National Environmental Health Service Submission Report

EHIS reference: 5995 **Applicant:** Milford Quarries Limited

Location: Clogrennane, Bilboa, Co. Carlow

Planning reference: FD01.324015

Figure 8-3: Site Drainage Map

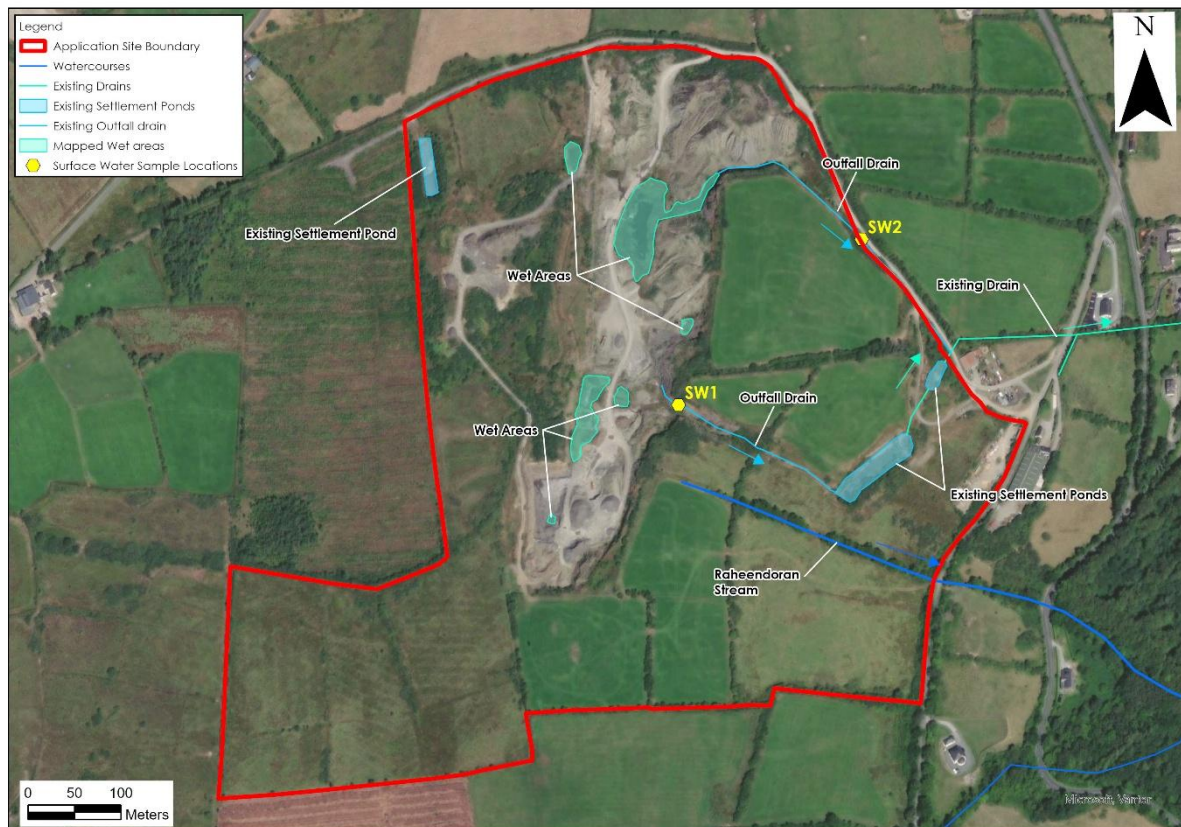
Any settlement lagoons should have been maintained and monitored carefully and should be constructed from the clayey subsoil that is present directly underneath the residual peat over much of the site and will operate as sealed lagoons. There is no

detail on the construction or management of lagoons throughout the operational phase of this quarry. This mitigation measure prevents a loss of water through the base of the lagoons and will prevent any silt fines from the lagoon(s) going to groundwater.

There is no information on the rate of dewatering, the pump specification or the location of discharge at the Site. The course of the Raheendoran Stream has been altered by the historic quarrying activities the drainage affect and groundwater distribution regarding this activity which was done without an EIA at the time needs careful consideration.

- A site-specific Environmental Management System should be implemented at the site by the applicant during this stage.
- Any settlement lagoons should be maintained and monitored carefully and should be constructed from the clayey subsoil that is present directly underneath the residual peat over much of the site and will operate as sealed lagoons. This mitigation measure prevents a loss of water through the base of

Figure 9.3: Annual Mean Dust Deposition Rate (mg/m²/day) – Proposed Operations Scenario

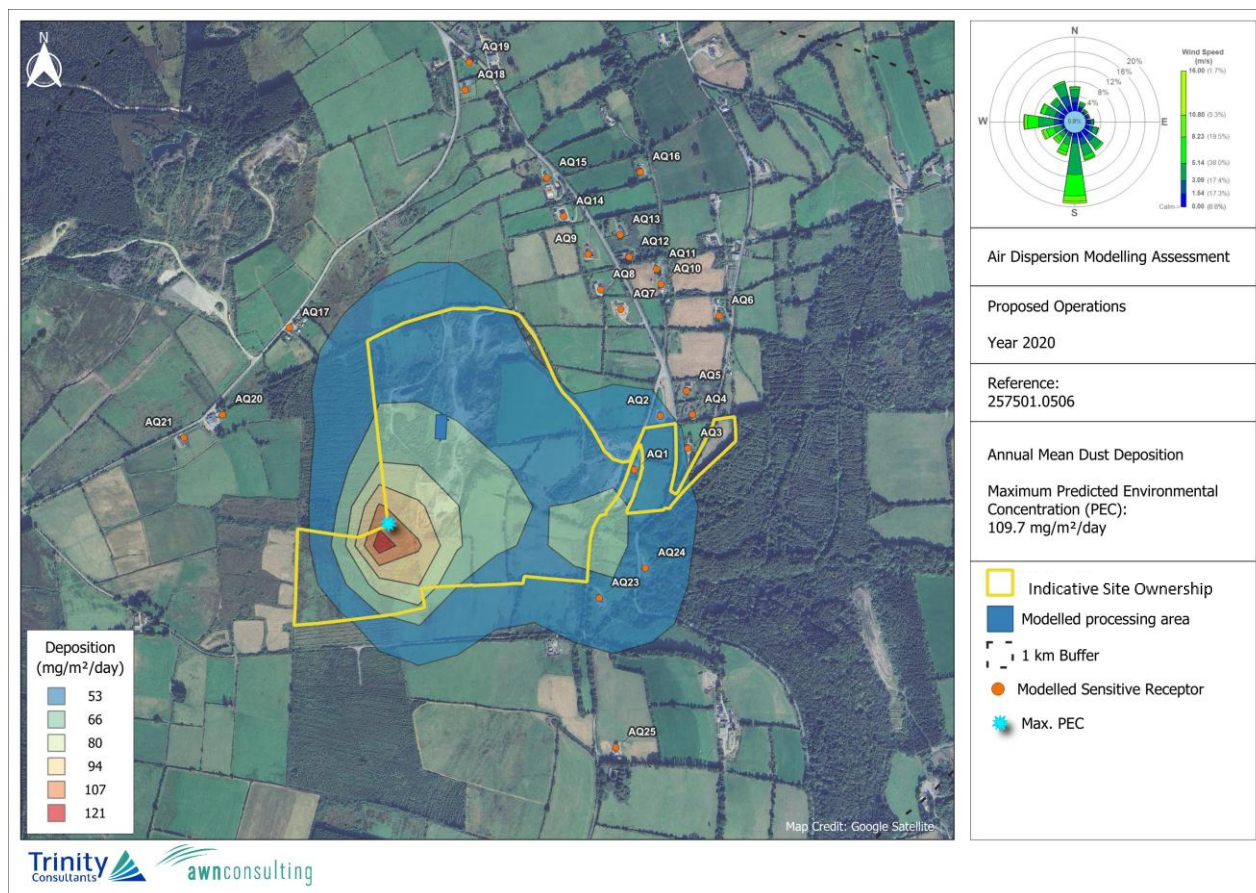
There is variability in the deposition rates recorded across the monitoring months and locations within data provided in the preparation of this EIAR. Furthermore, all monitoring was completed after quarrying activities ceased. As such, the quarry's contribution of recorded deposited dust is not represented within the monitoring data.

The baseline air quality in 2000 is potentially different to that of the presented data from 2024. The baseline at the start of the unauthorised activities was the original air quality together with any contribution from the years of quarry activity, together with any cumulative activity from other quarries/industry within the area was not assessed prior to this development.

The NEHS recommends the **TA Luft limit value of 350 mg/m²/day** to be adopted to evaluate potential dust deposition impacts from the operational phase of the quarry and extension if granted.

Figure 3.4. Restoration of the proposed development site.

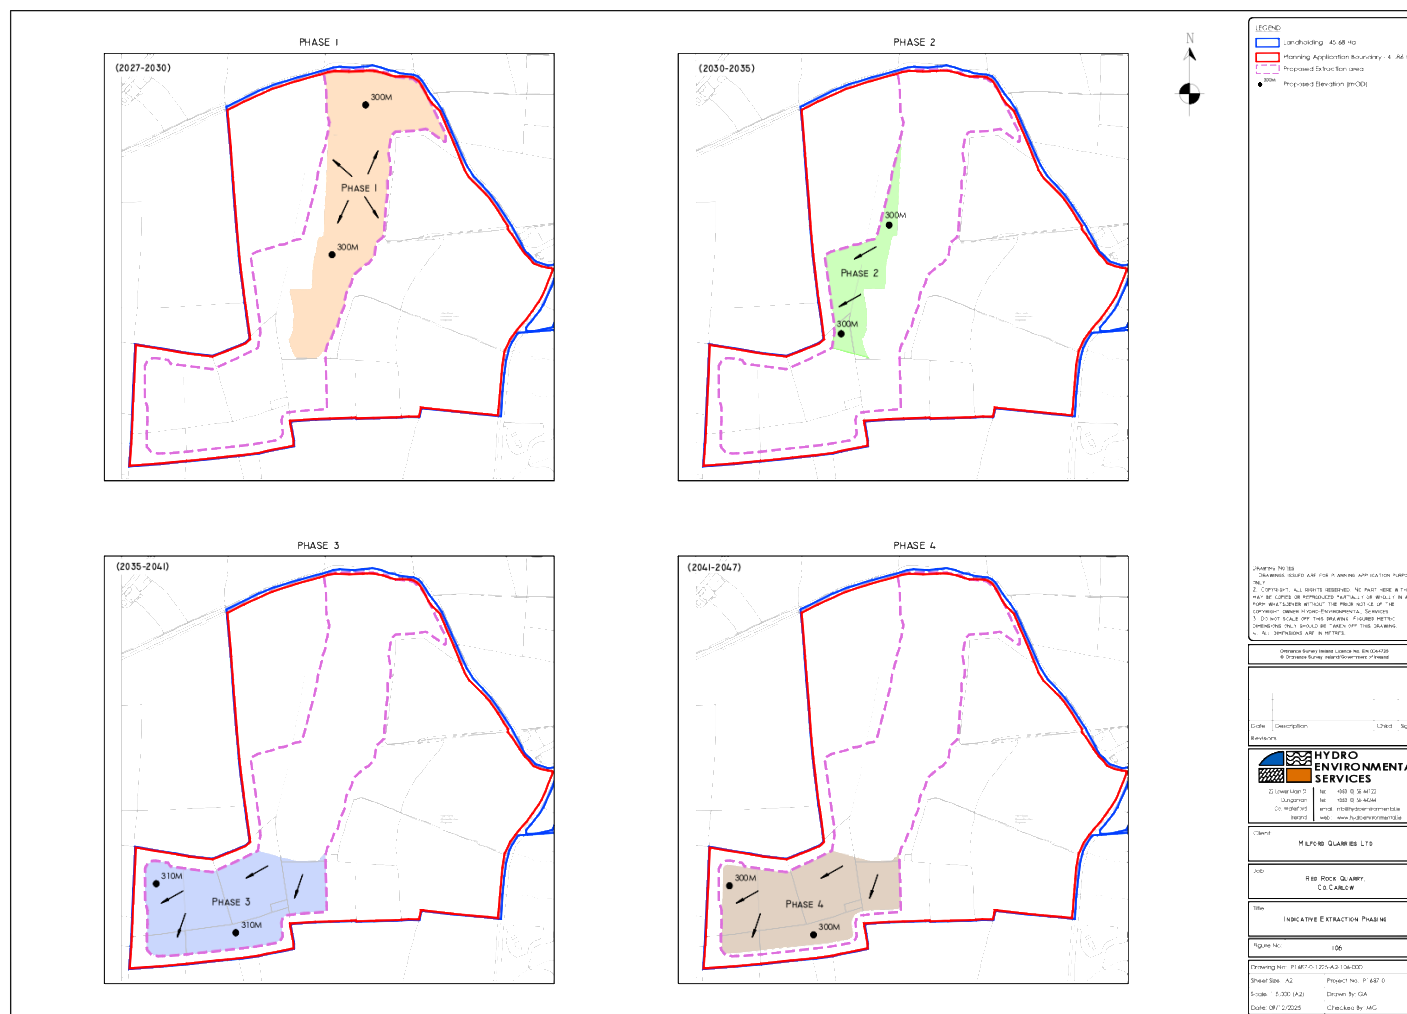
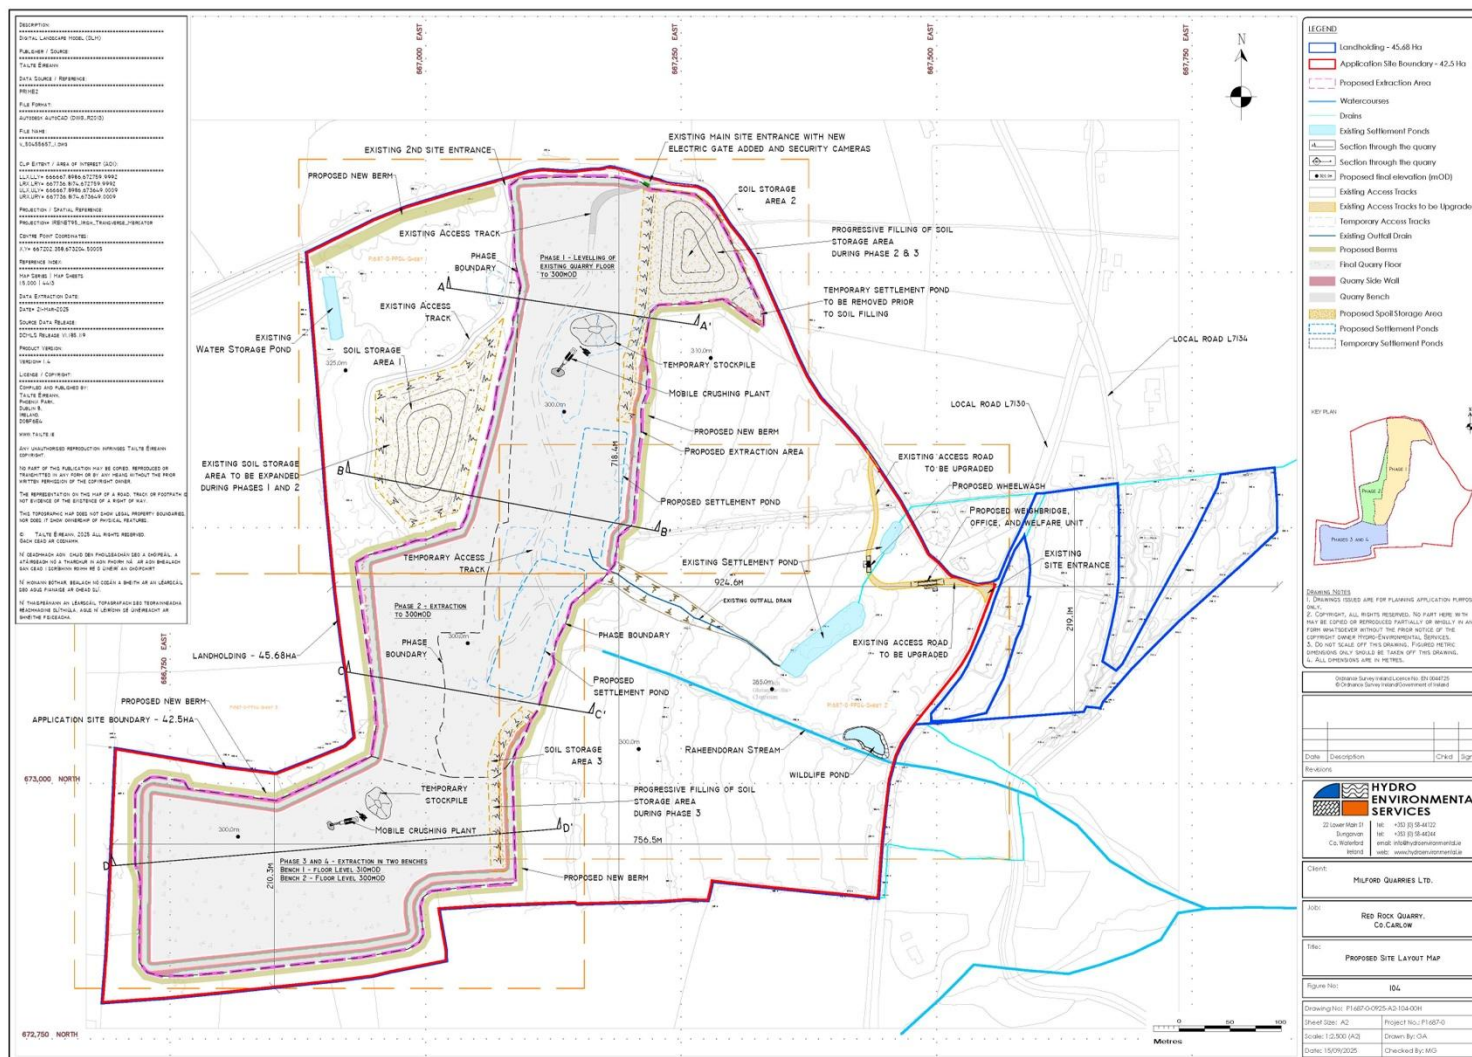
There is not in great detail on the restoration process or full detailed plans. The map provided is not comprehensive. The Environmental Management Plan should lay out how the retained habitats will be protected during extraction; how continued management is undertaken post restoration and how the results are monitored to allow management revisions as necessary. This monitoring should be undertaken for the first 5 years after restoration.
